PLANNING BOARD REPORT PORTLAND, MAINE

Munjoy Heights

Level III Site Plan and Subdivision

Submitted to: Portland Planning Board Public Hearing Date: December 17 th , 2013	Prepared by: Jean Fraser, Planner Date: December 13 th , 2013 Planning Board Report # 57-13
---	---

DRAWING NO. **C-30**

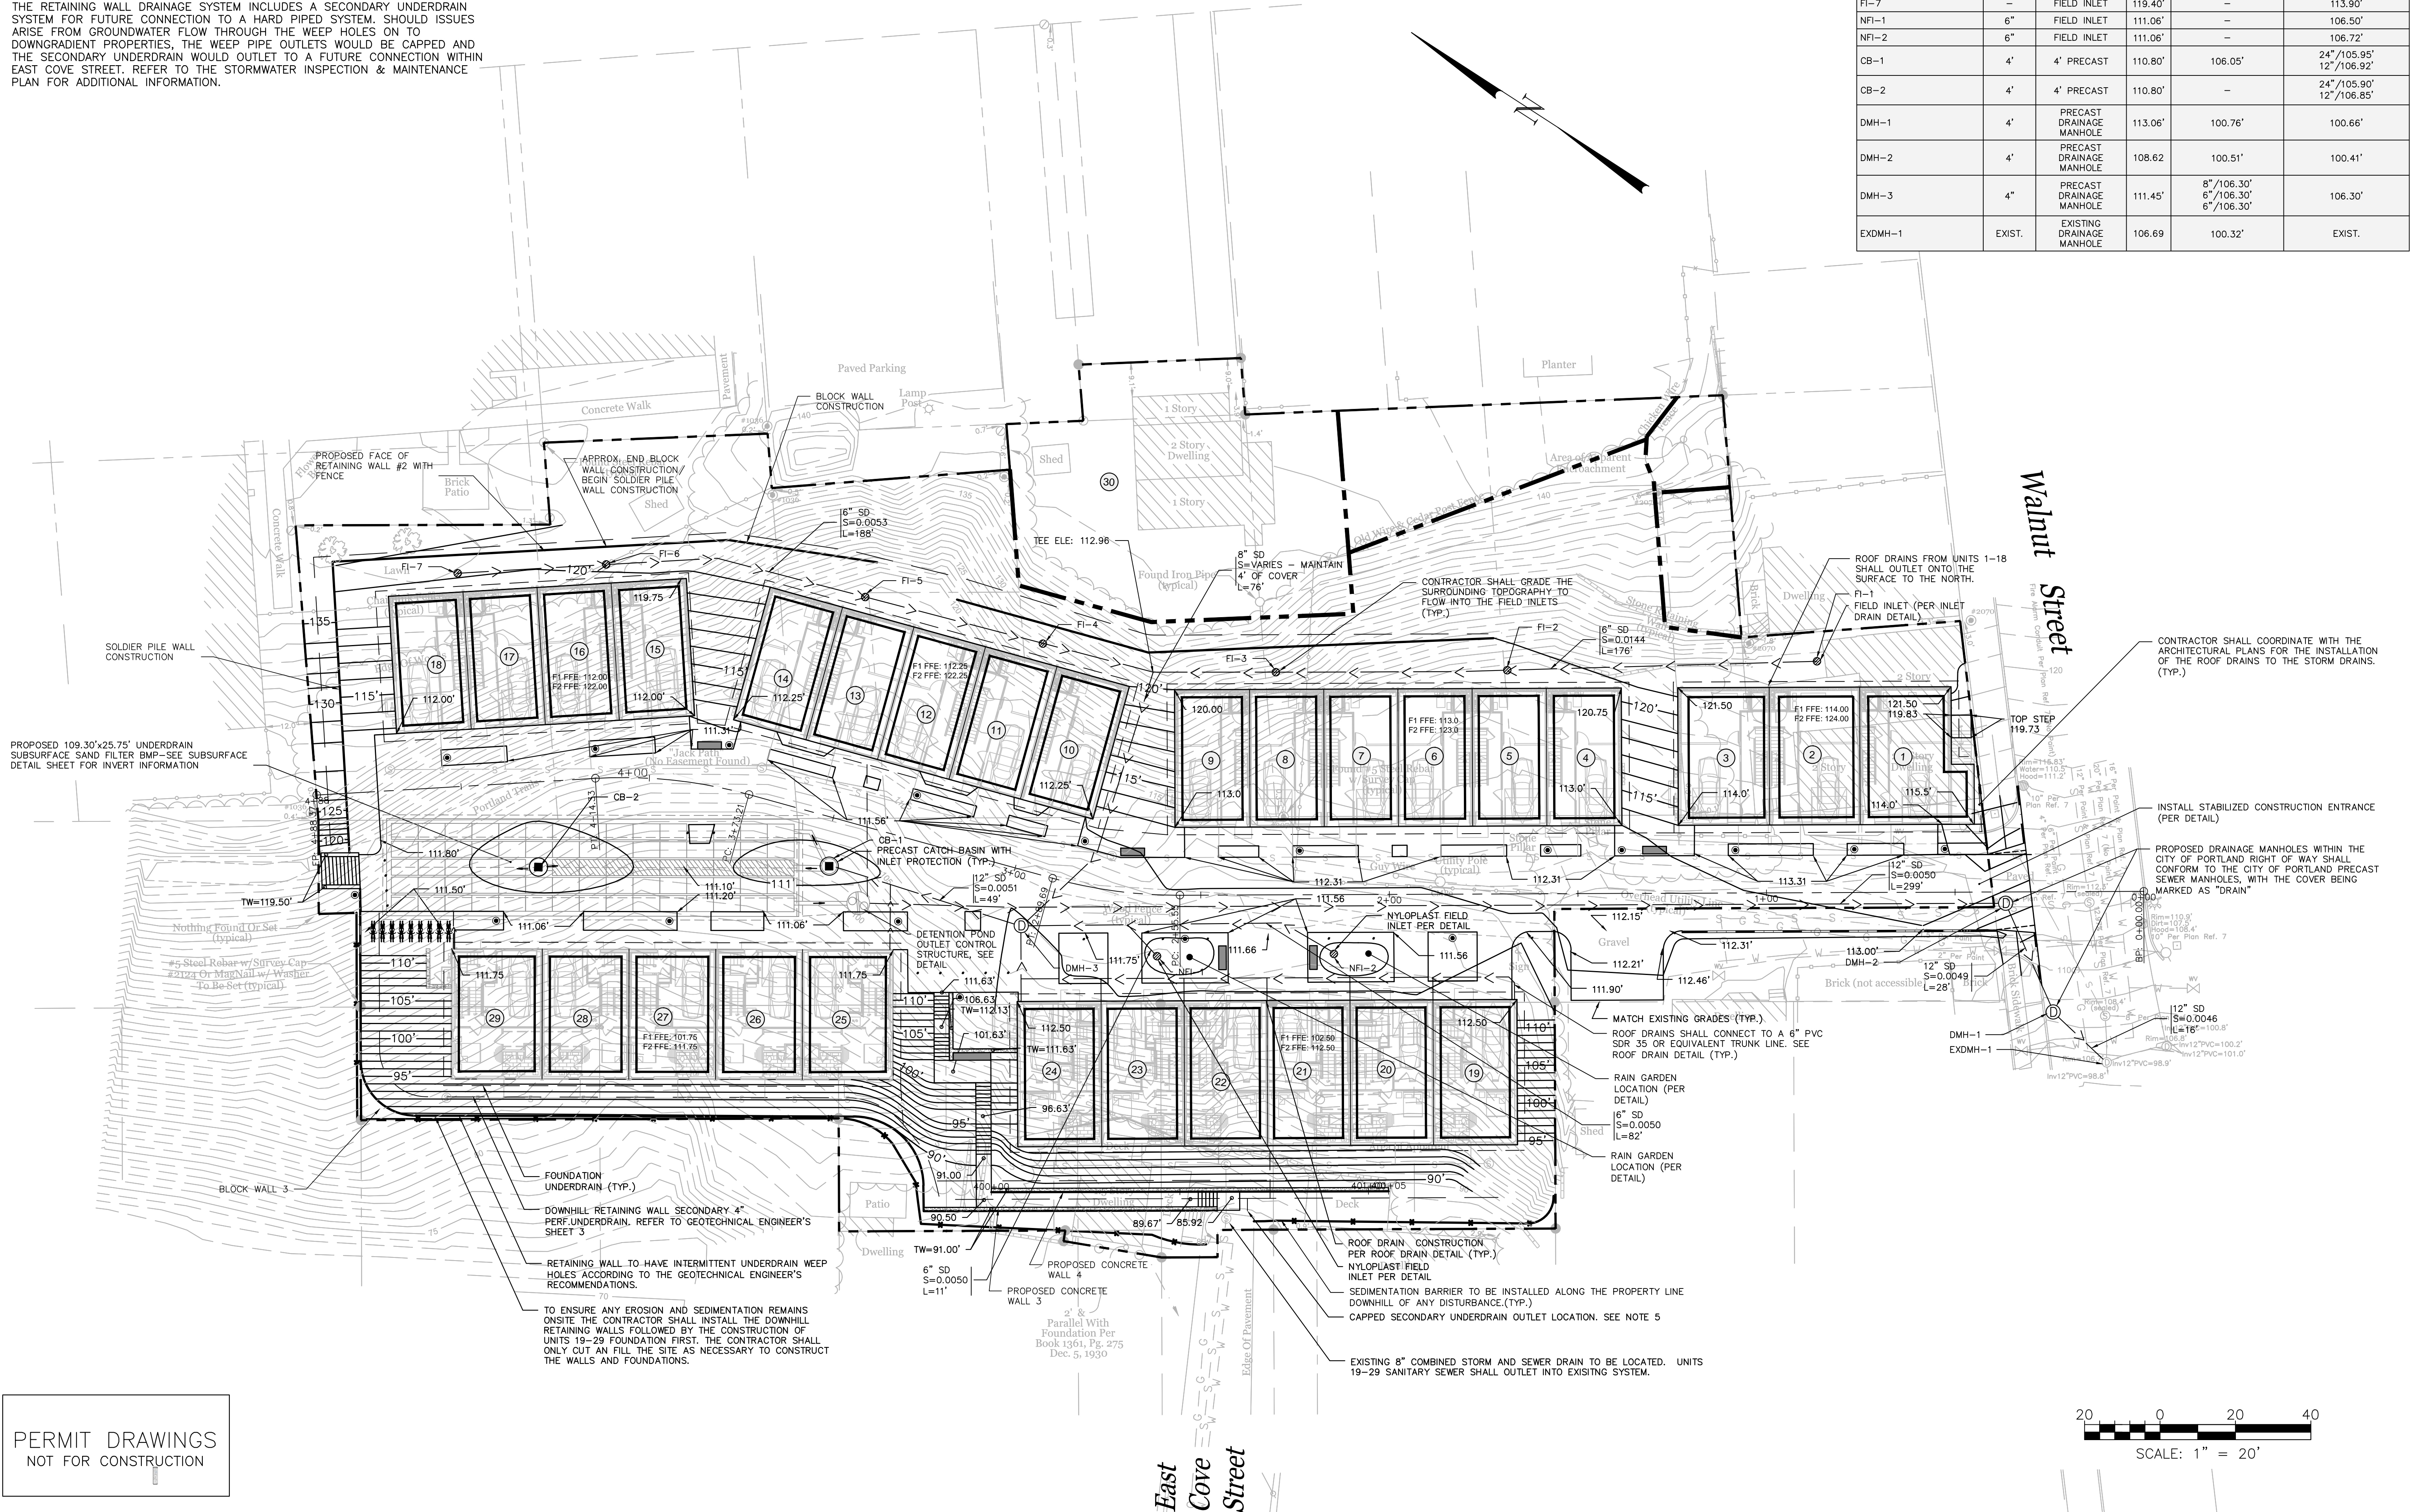
Consulting Engineer Dave Senus has confirmed (Attachment 2) that the applicant has provided a detailed Erosion and Sediment Control Plan for the project as part of their mid-November submittal (Attachment J). This, in addition to the submitted Construction Management Plan (Plan 36); C-30 GRADING, DRAINAGE & EROSION CONTROL PLAN (Plan 8); and C-43 EROSION CONTROL DETAILS & NOTES (Plan 13) sufficiently address erosion and sediment control practices and approach. The applicant has addressed specifically the sequence of construction work to minimize impact on downhill properties.

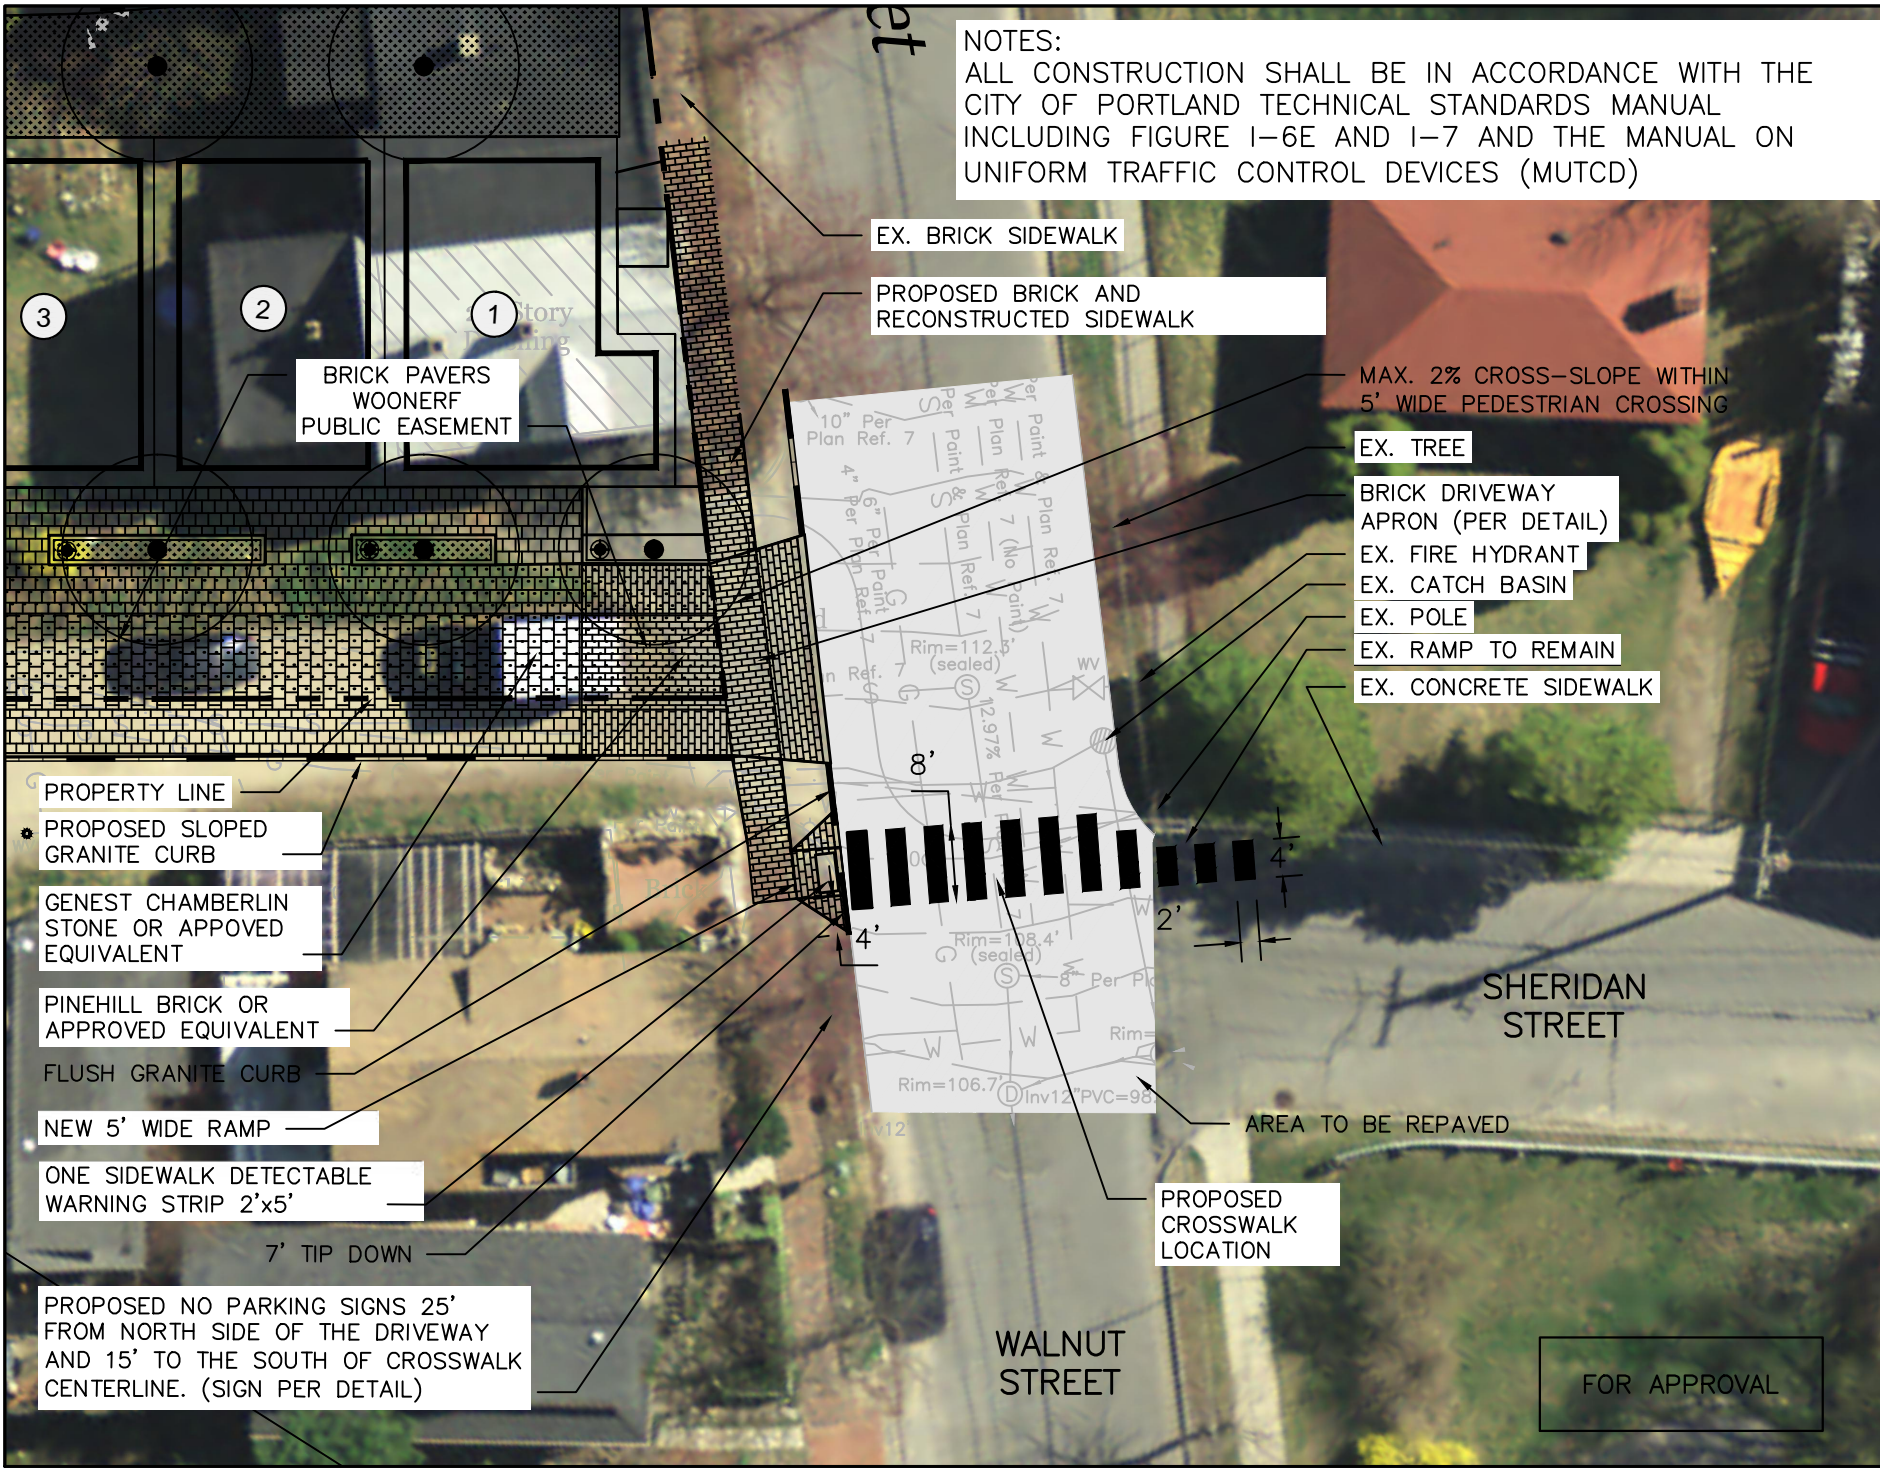
Tom Errico, Traffic Engineering reviewer, raised some concerns during the review and has concluded that the final plans should be revised to ensure safe pedestrian use and winter maintenance of the sidewalk:

It is recommended that the radii be eliminated from the plans and standard tip down curbing be provided. This change deviates for City standards, but I support a waiver from our technical standards to allow for optimal sidewalk alignment along Walnut Street and to ensure easier routing of sidewalk snow plows (this subject sidewalk is a school walking route and maintenance and function are a priority). ([Attachment 1](#))
